Final Plat Drawings_v1.pdf Markup Summary

Project Name: McGehee Subdivision

MCGEHEE SUBDIVISION
LDC Project No. 20018

LETTER OF INTENT

Lot 3, "MOUNTAIN SHADOW RANCH SECOND PHASE" (Reception No. 200072526)

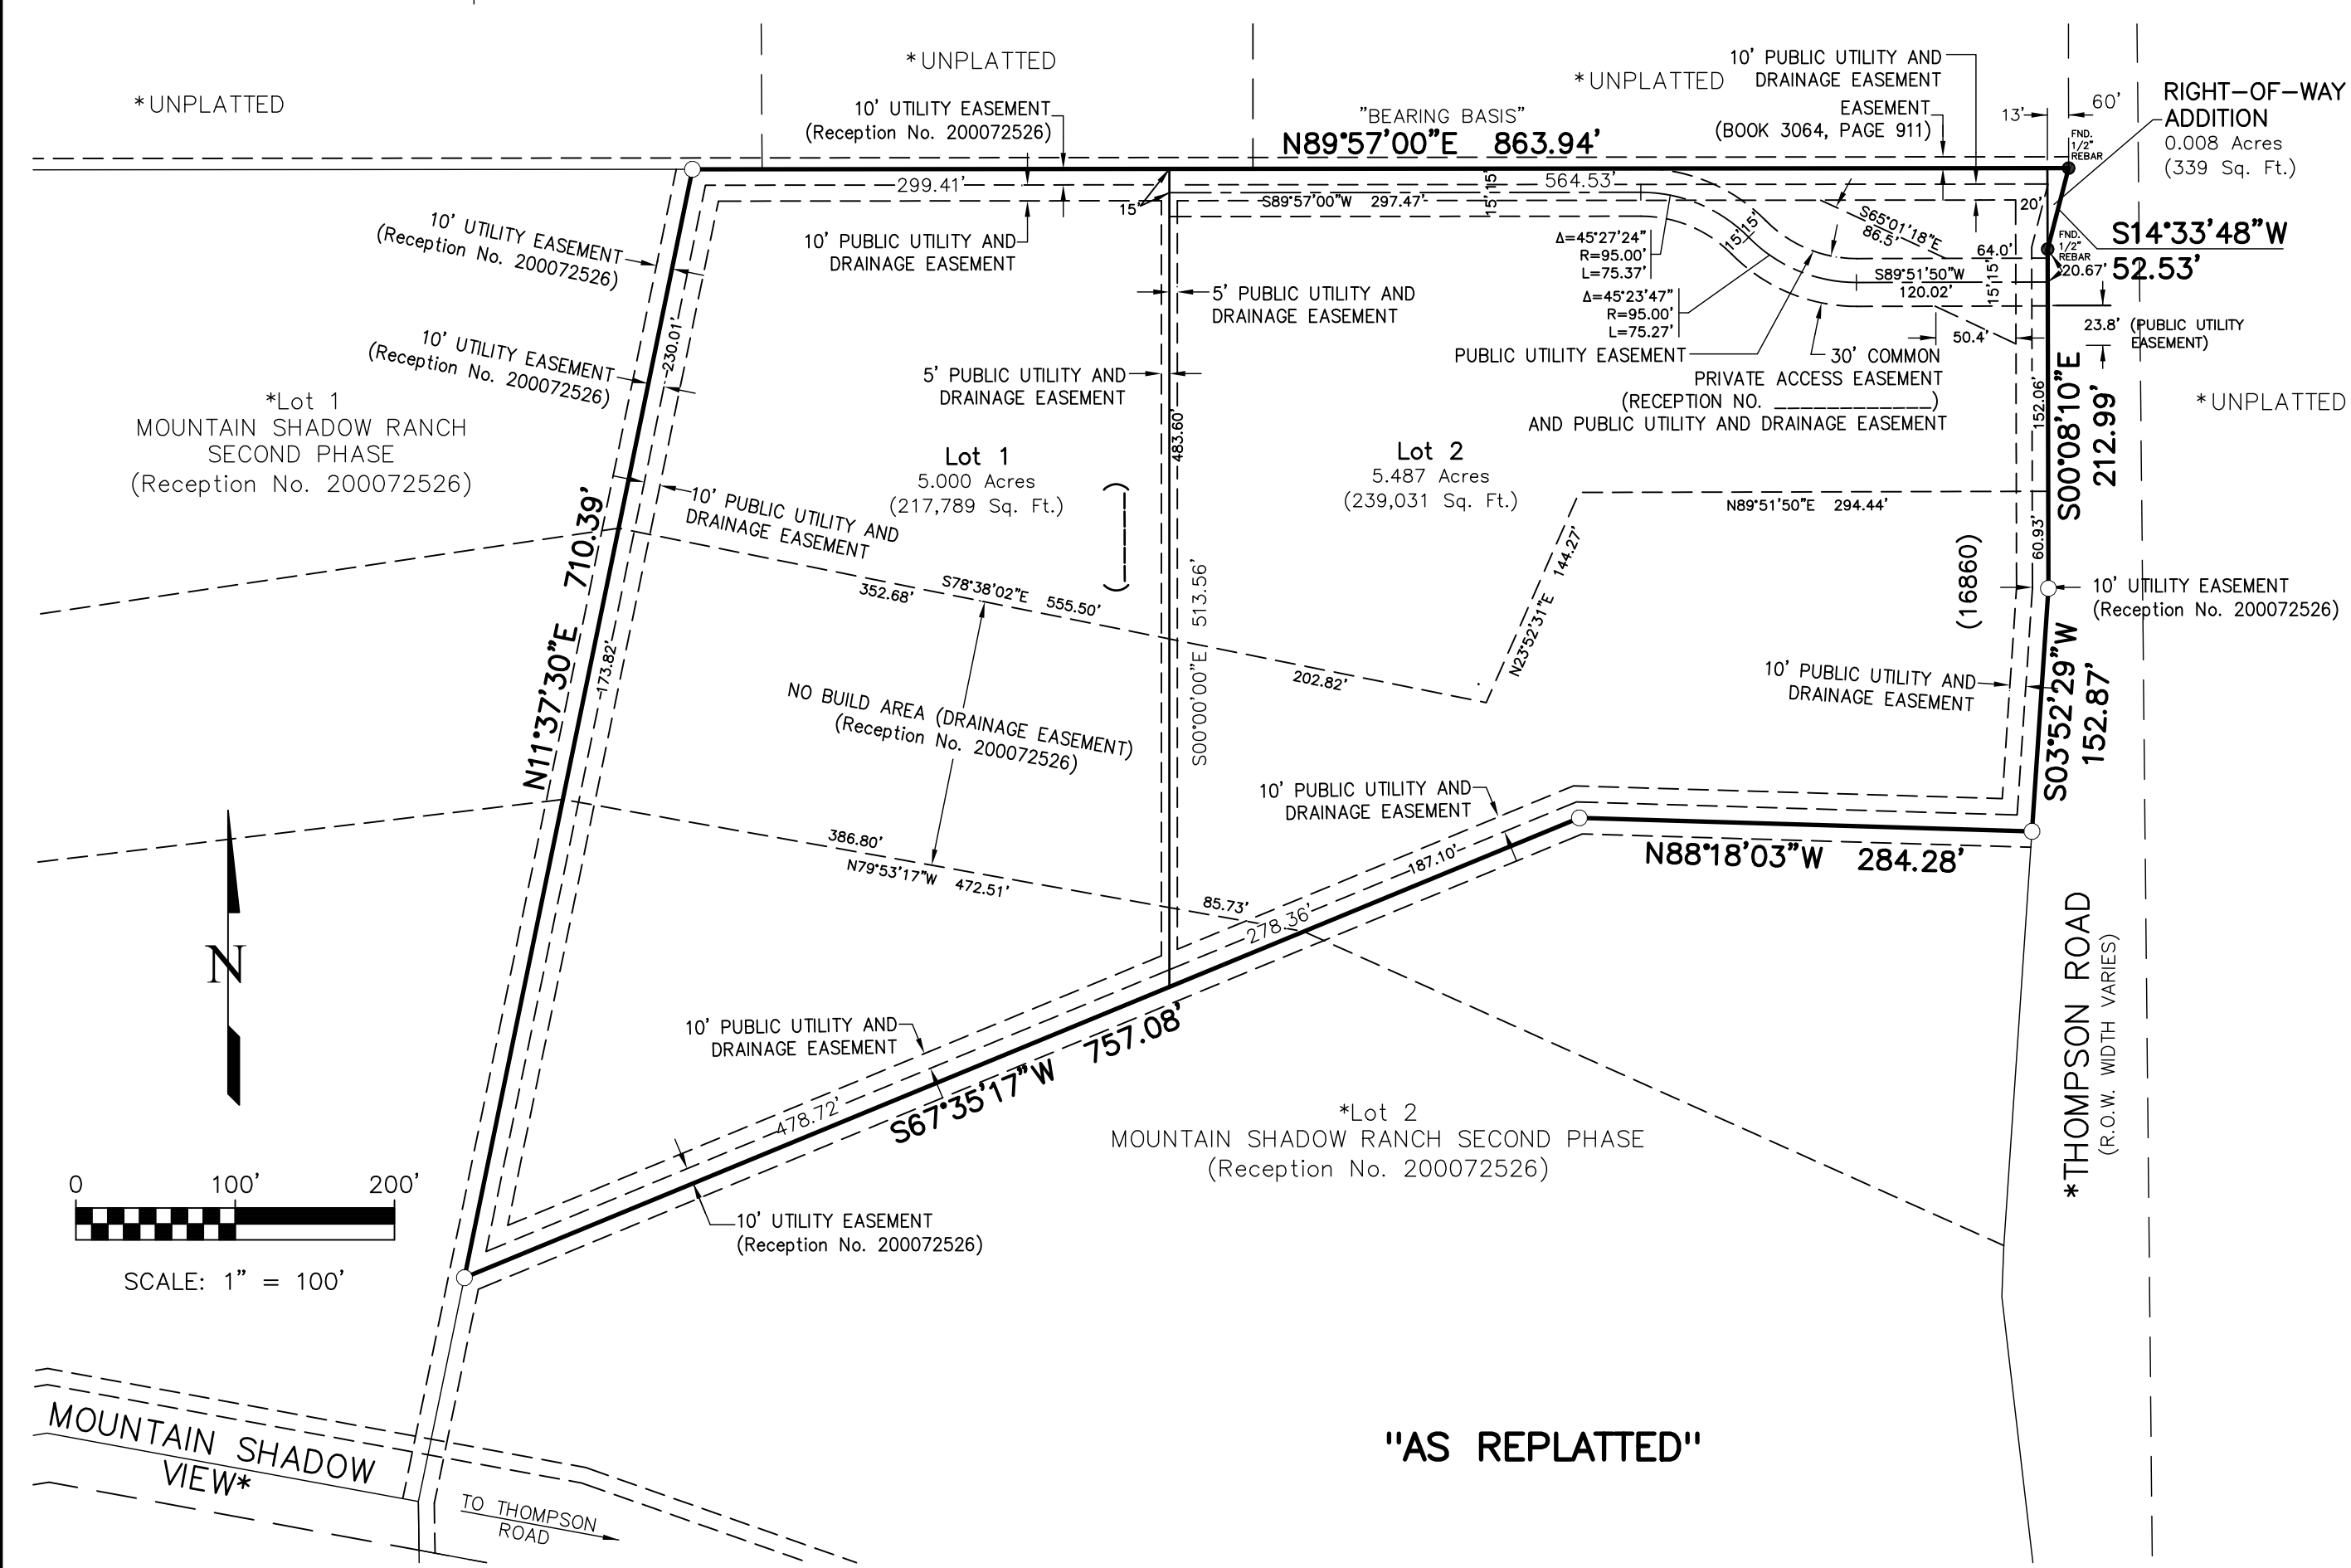
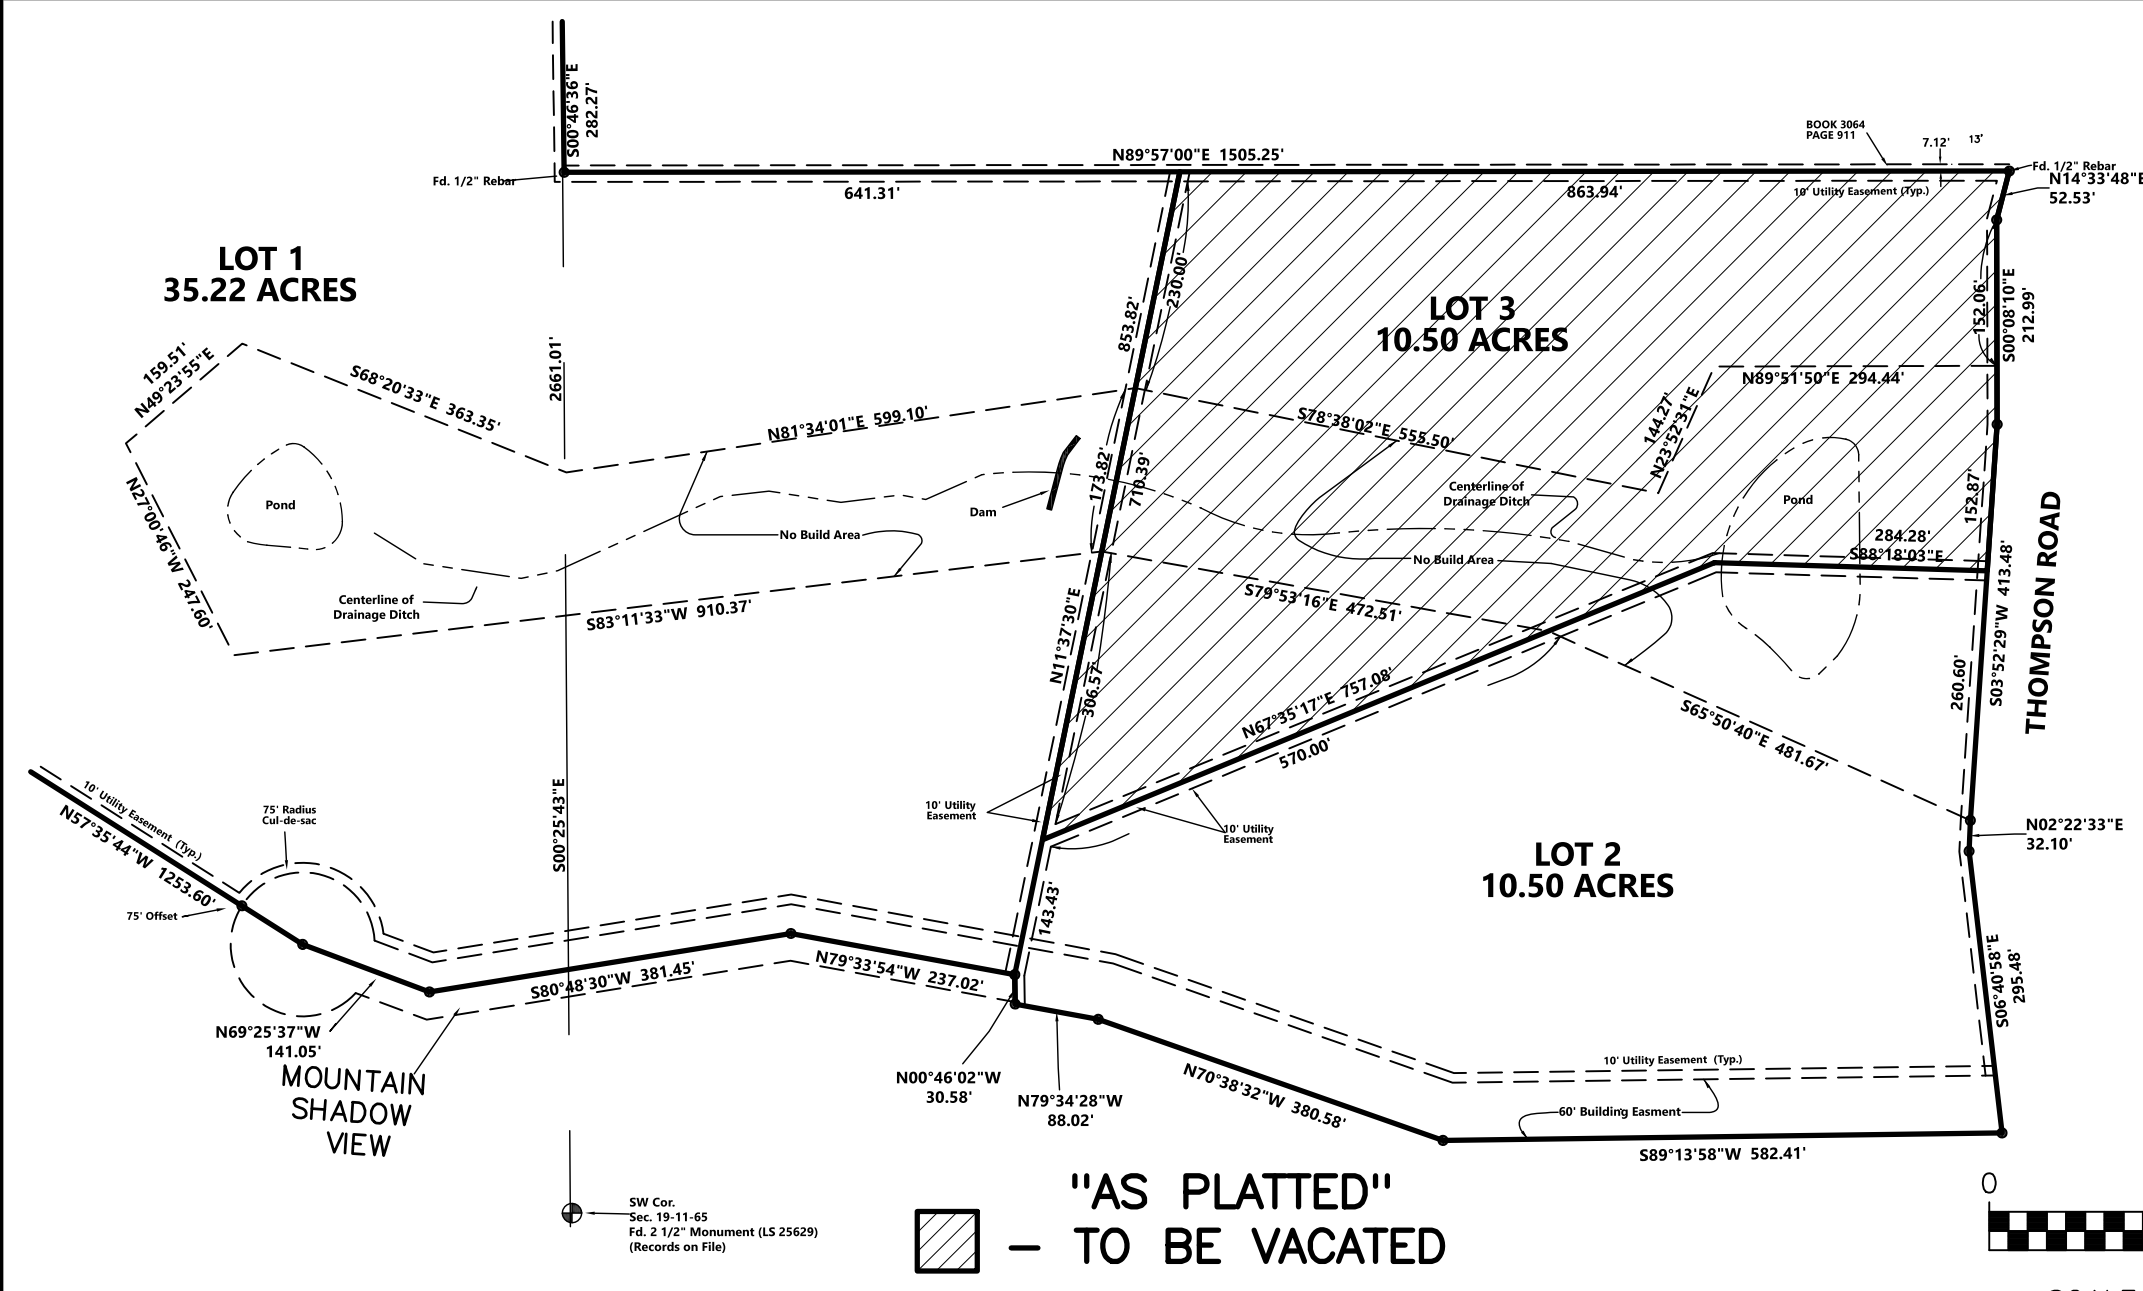
Change to "As replatted"

CHANGED - DVH

Include square footage

Revise to 20-foot dedication per MVEA
 Commitment letter

Add note regarding wastewater treatment system
 and shallow groundwater identified in OWTS report

INCLUDED - DVH

REVISED - DVH

ADDED WITHIN NOTE 15 - DVH
